**SPRINGS AT WATERVIEW - AMENDED STORM**

GRINNELL DITCH NORTH - PLAN / PROFILE

GRINNELL DITCH SOUTH PROFILE

**STORM B PROFILE**

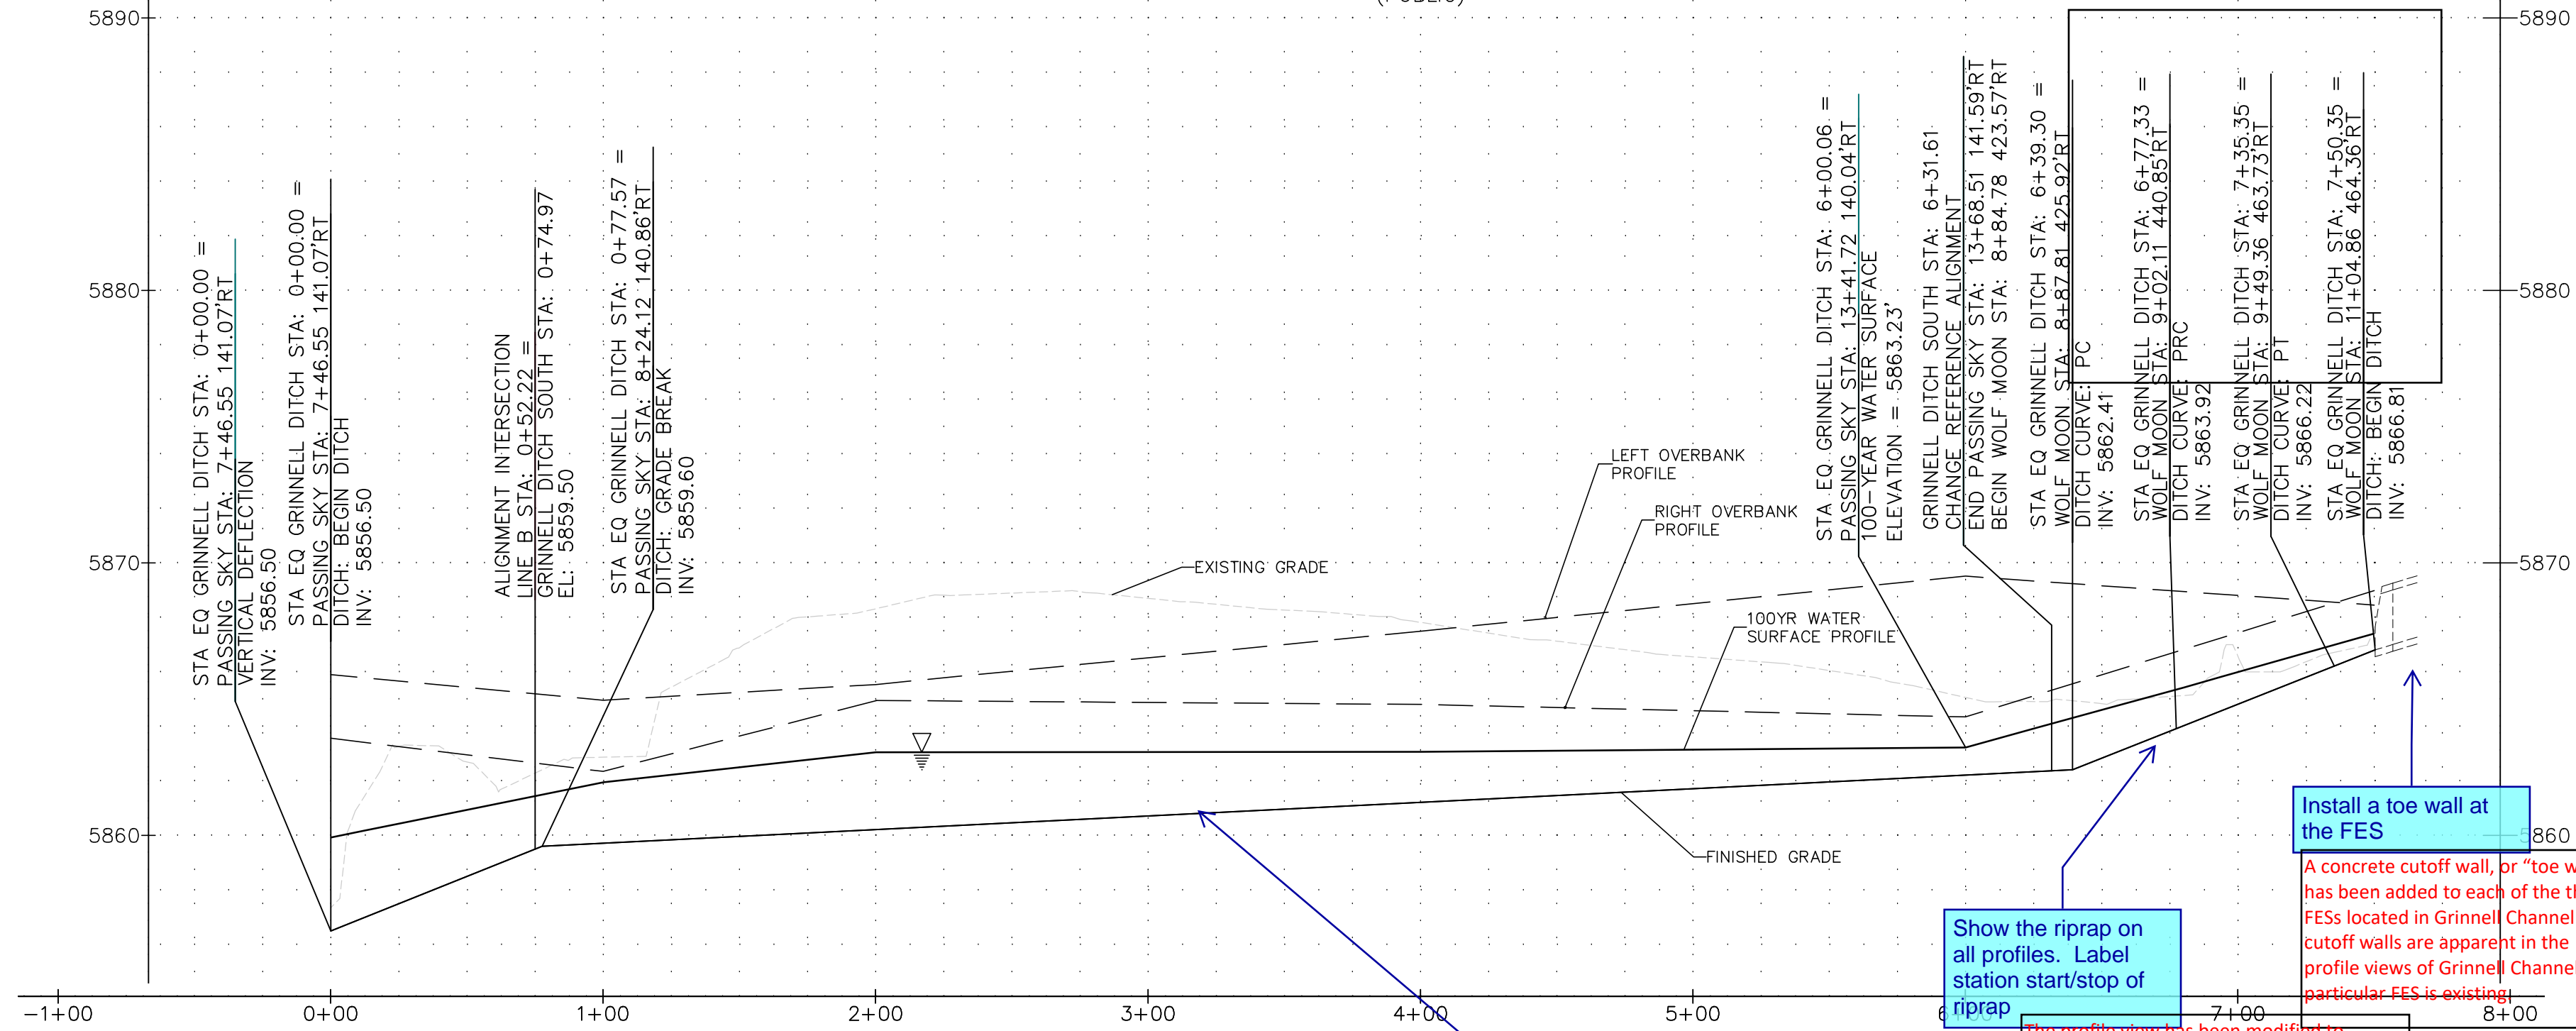
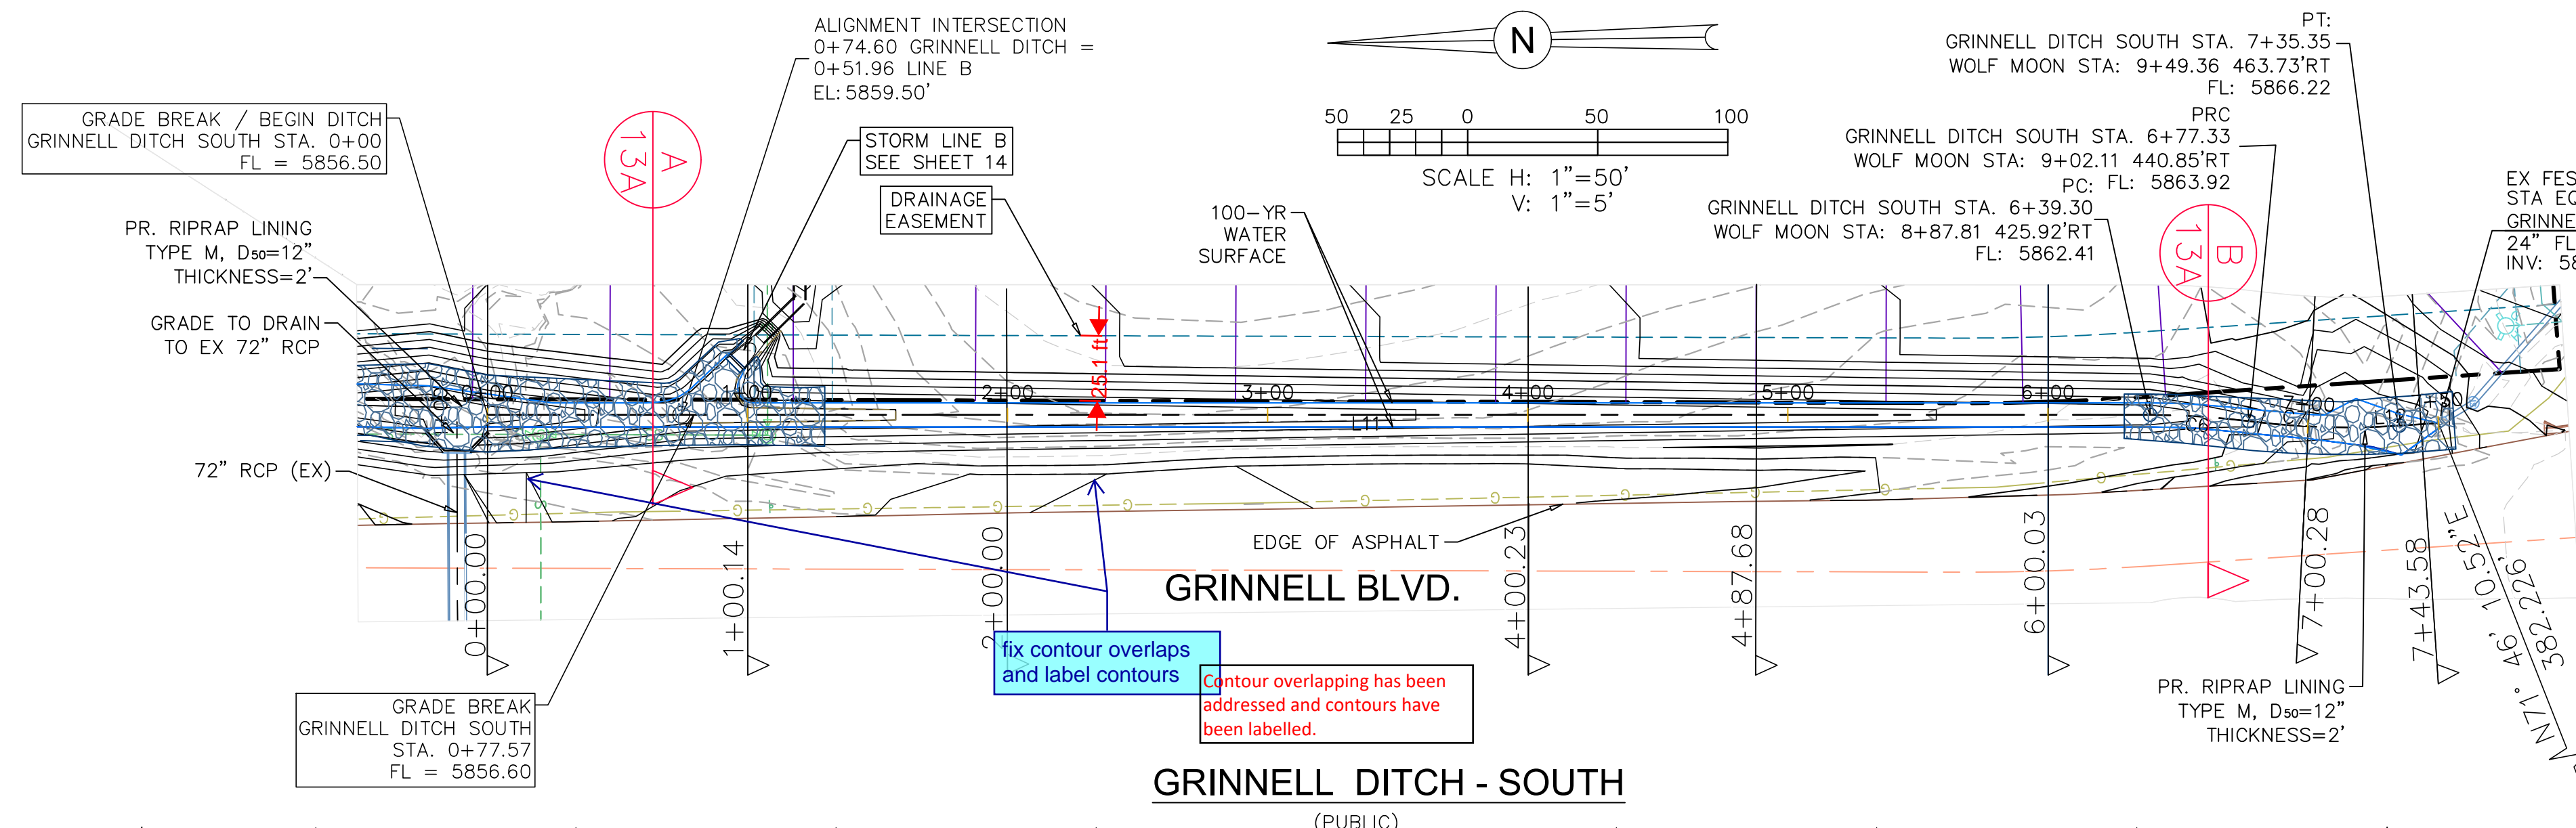
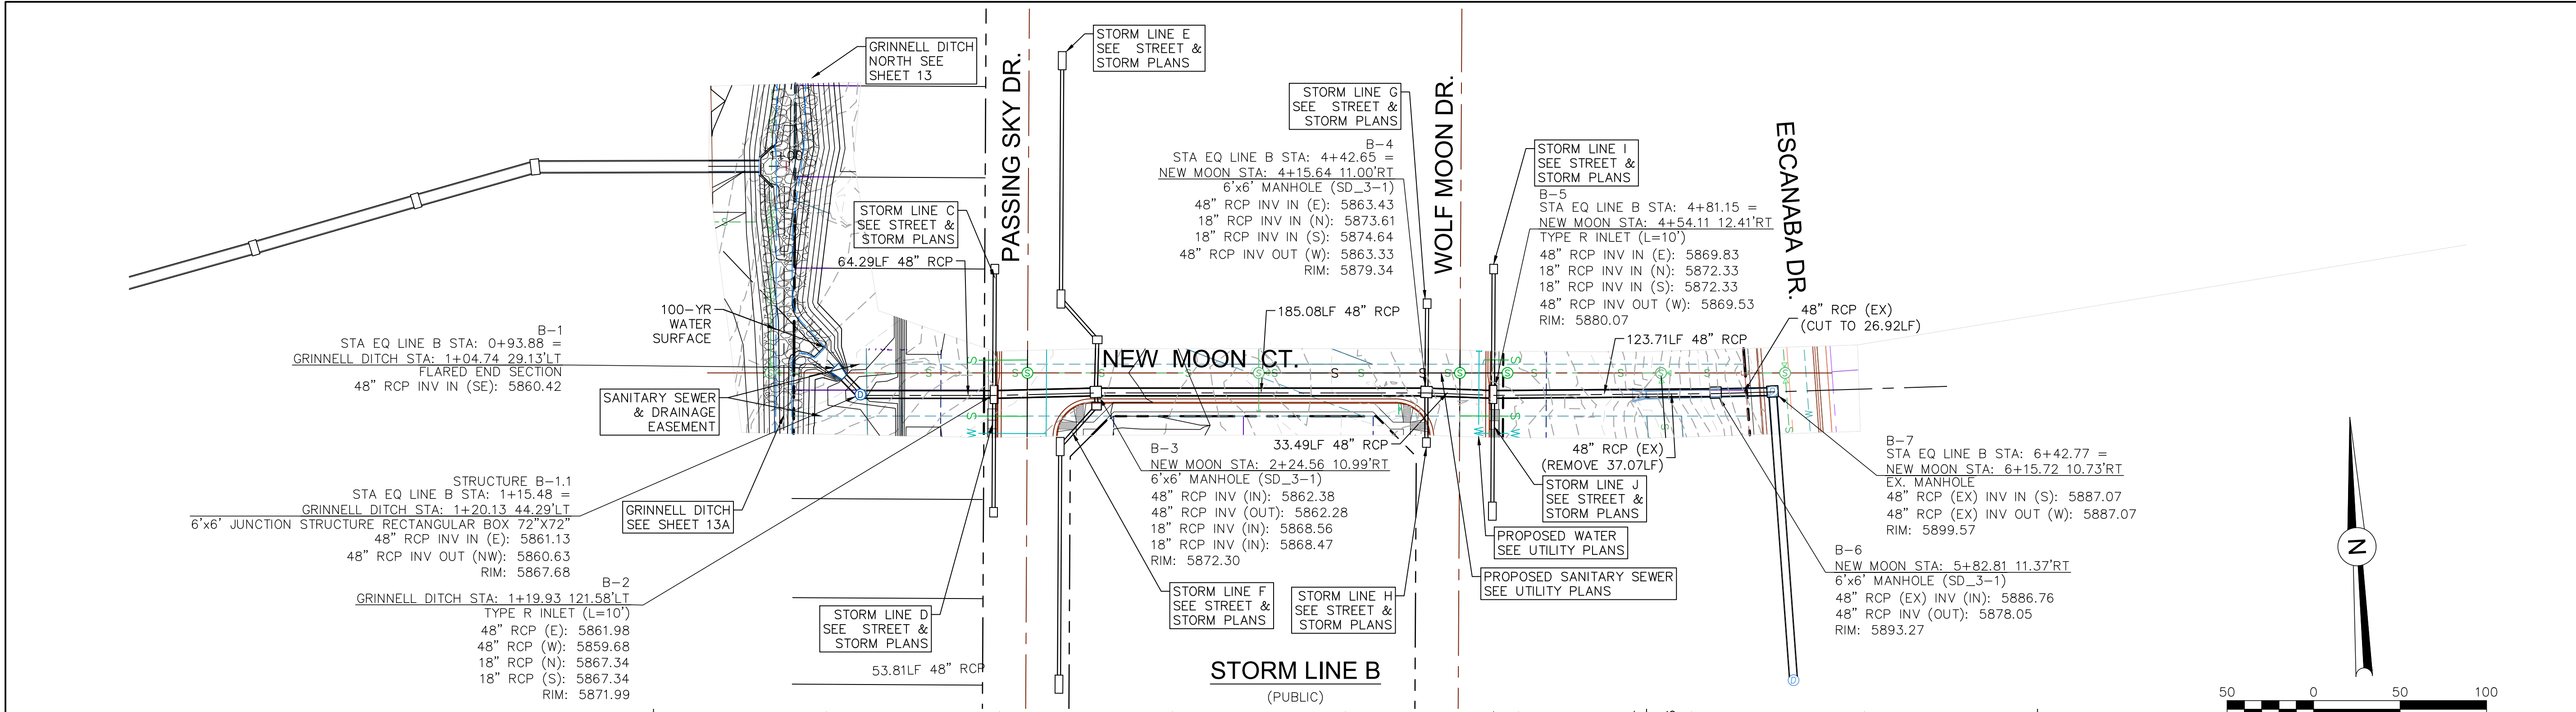
Provide delta angle

Show the riprap on all profiles. Label station start/stop of riprap

Install a toe wall at the FES

plan view indicates this is edge of asphalt, not ROW

label slopes

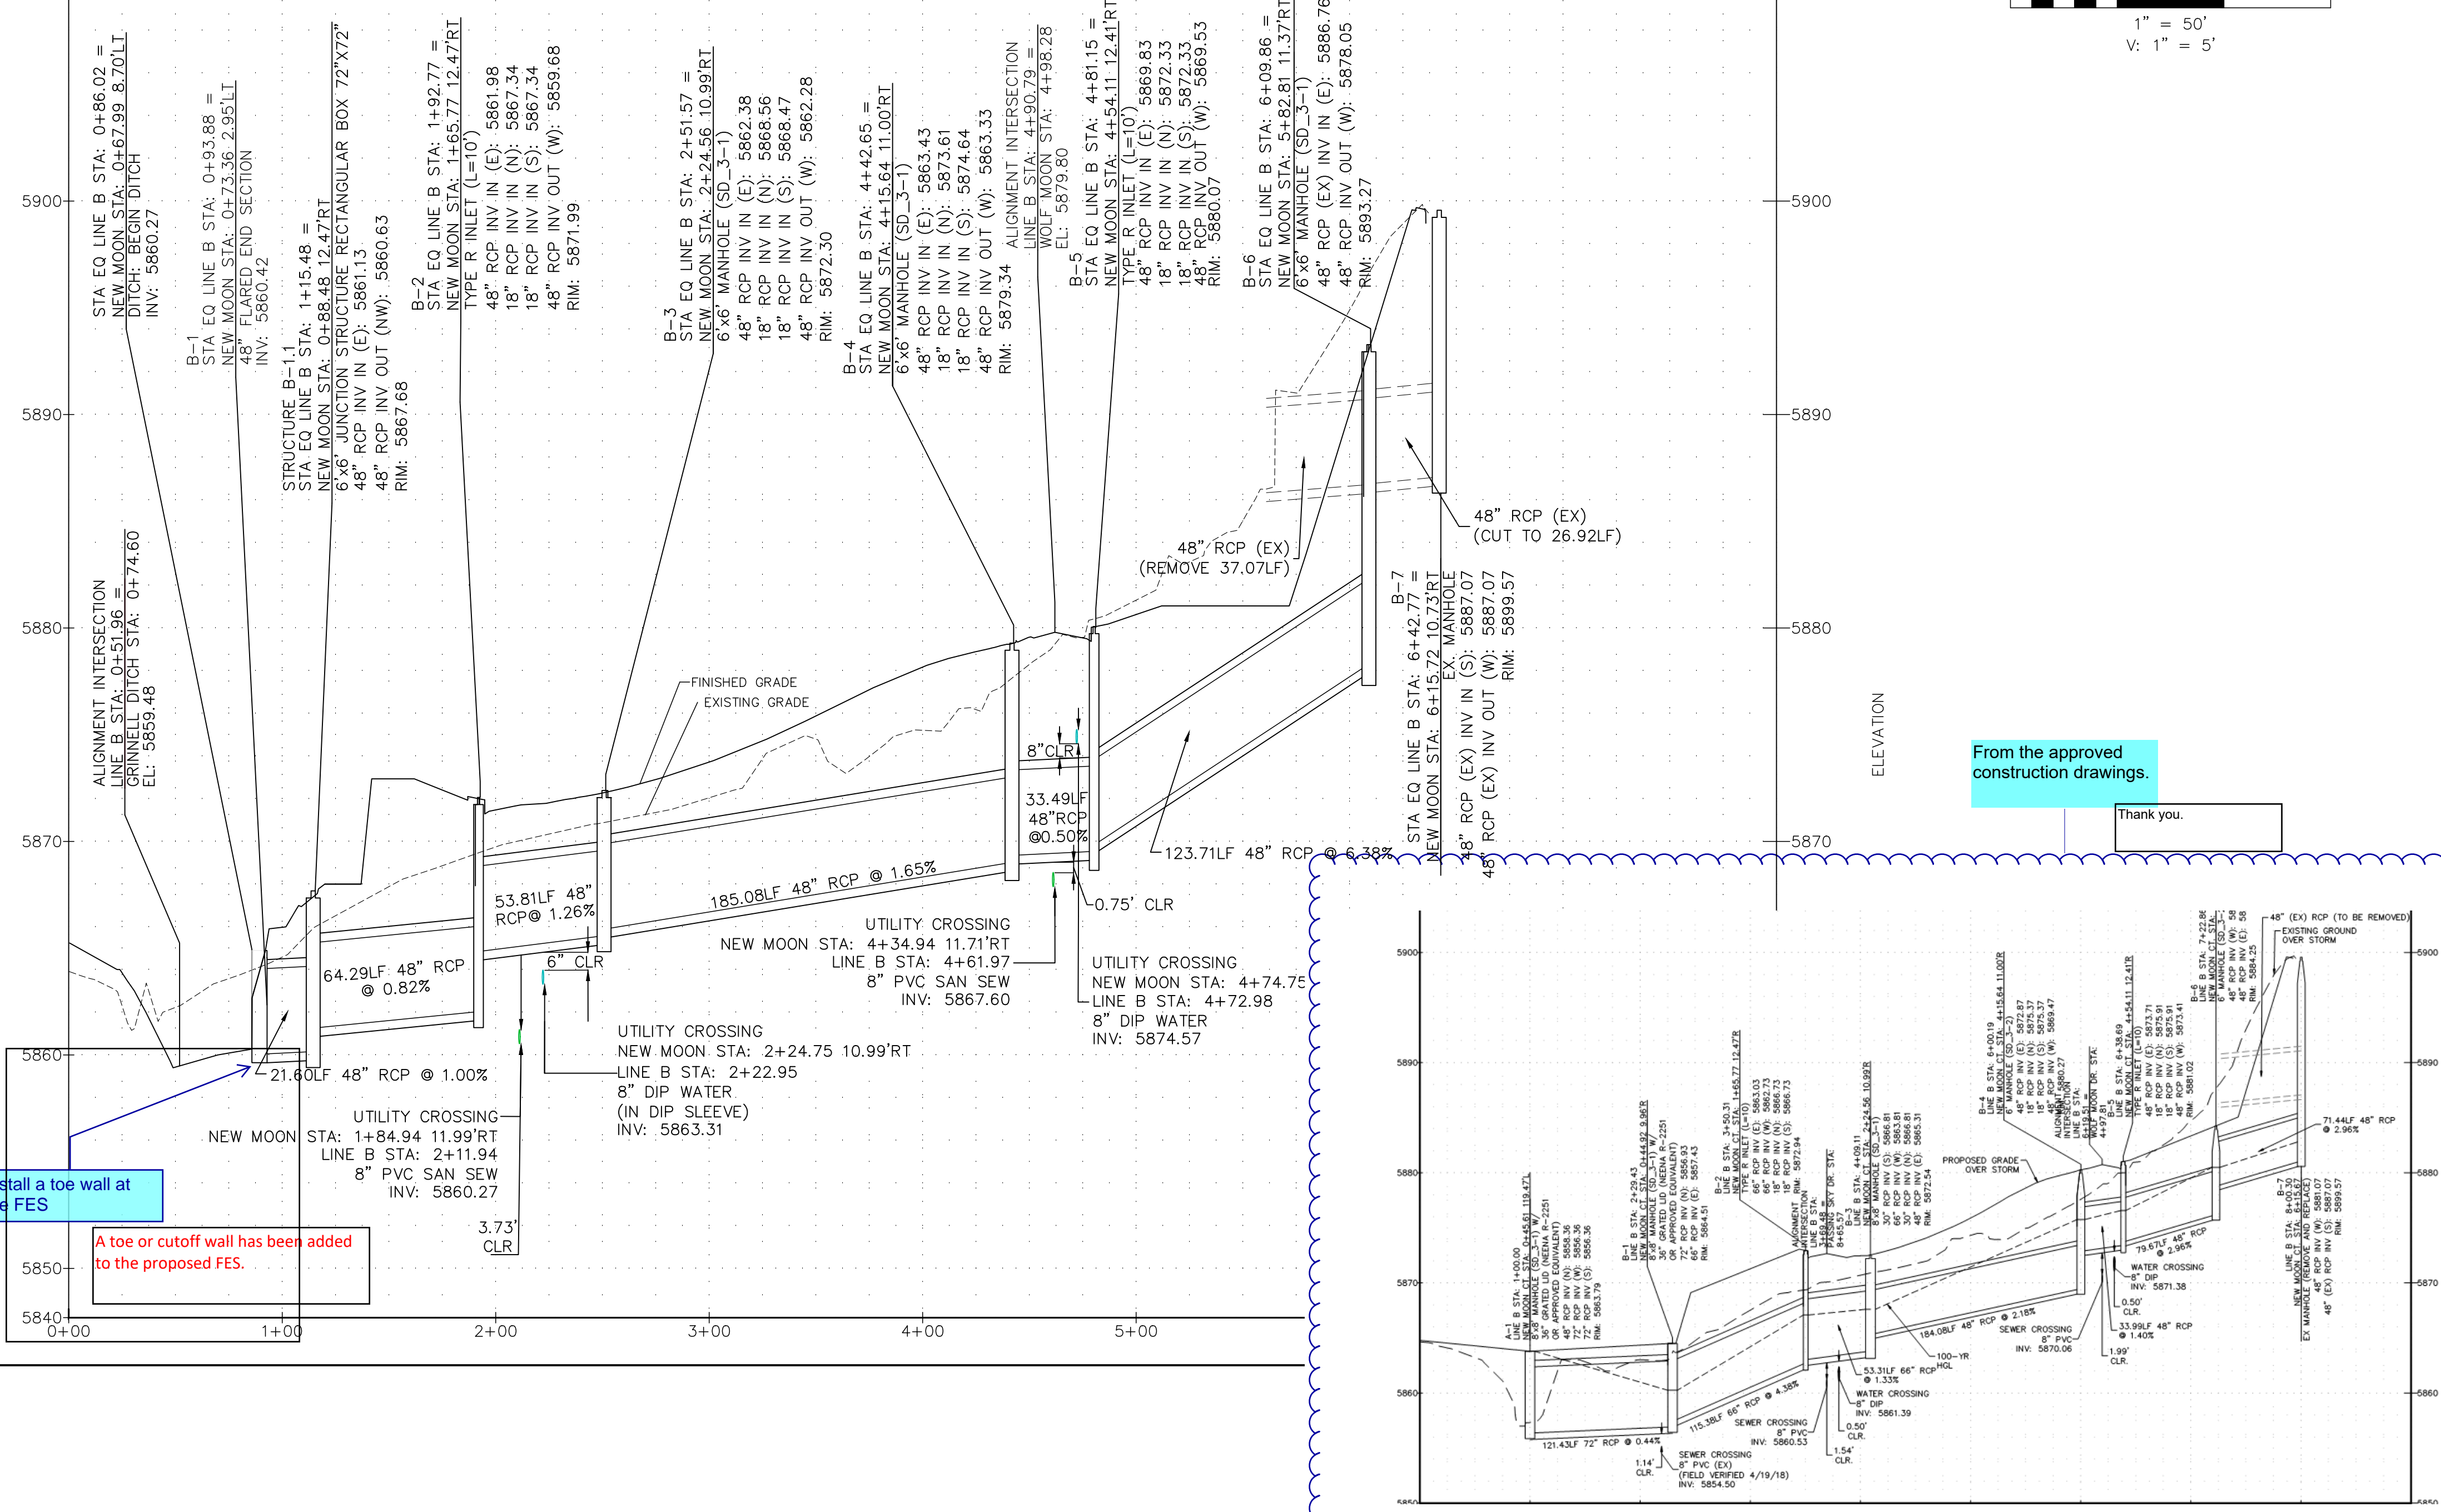
Draw revision cloud around the elements that are revised from the originally approved design.

This entire stormline B is completely altered from the originally approved report. Update the drainage letter to have the supporting narrative and calculations.

Install a toe wall at the FES
